Norwich to Tilbury Development Consent Order

Norwich to Tilbury
Development Consent Order

Landscape and Visual Technical Note

On behalf of Villages against Pylons

Title:  
 Figure 7.12.F83\_VP3.14a  
 Viewpoint 3.14: Lodge Lane, Ardleigh  
 Reservoir

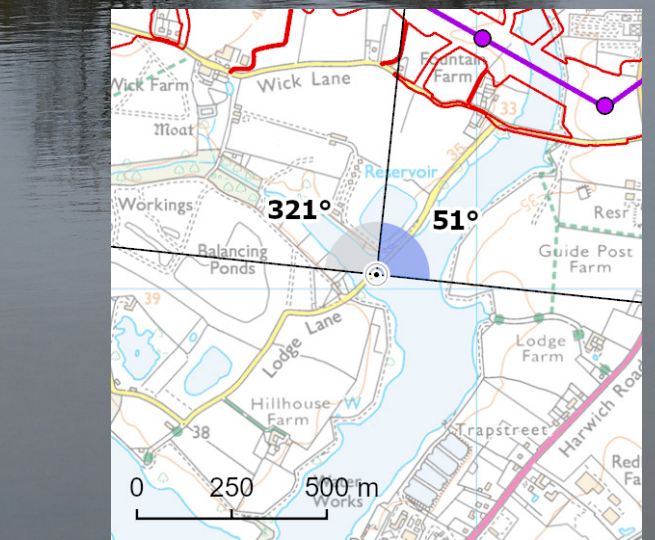
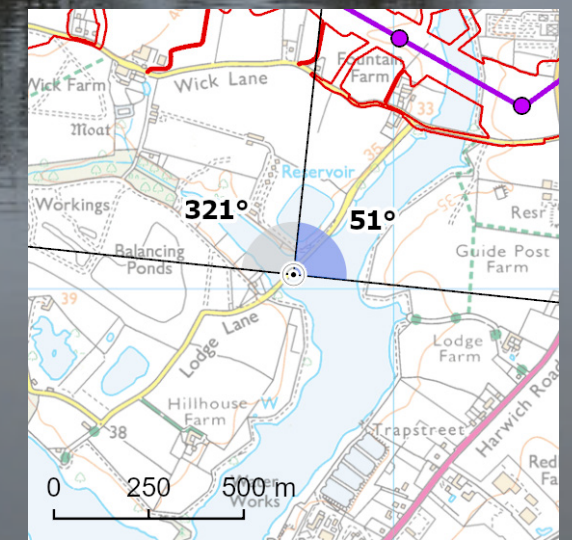
This conclusion is reinforced by the Applicant's own visual assessment findings. The assessment identifies major adverse effects from Viewpoints 4.14, 4.24, 4.25 and 4.30 (Document: 6.13.A3 Environmental Statement Appendix 13.3 – Visual Baseline and Assessment - Part 3), demonstrating that in a number of
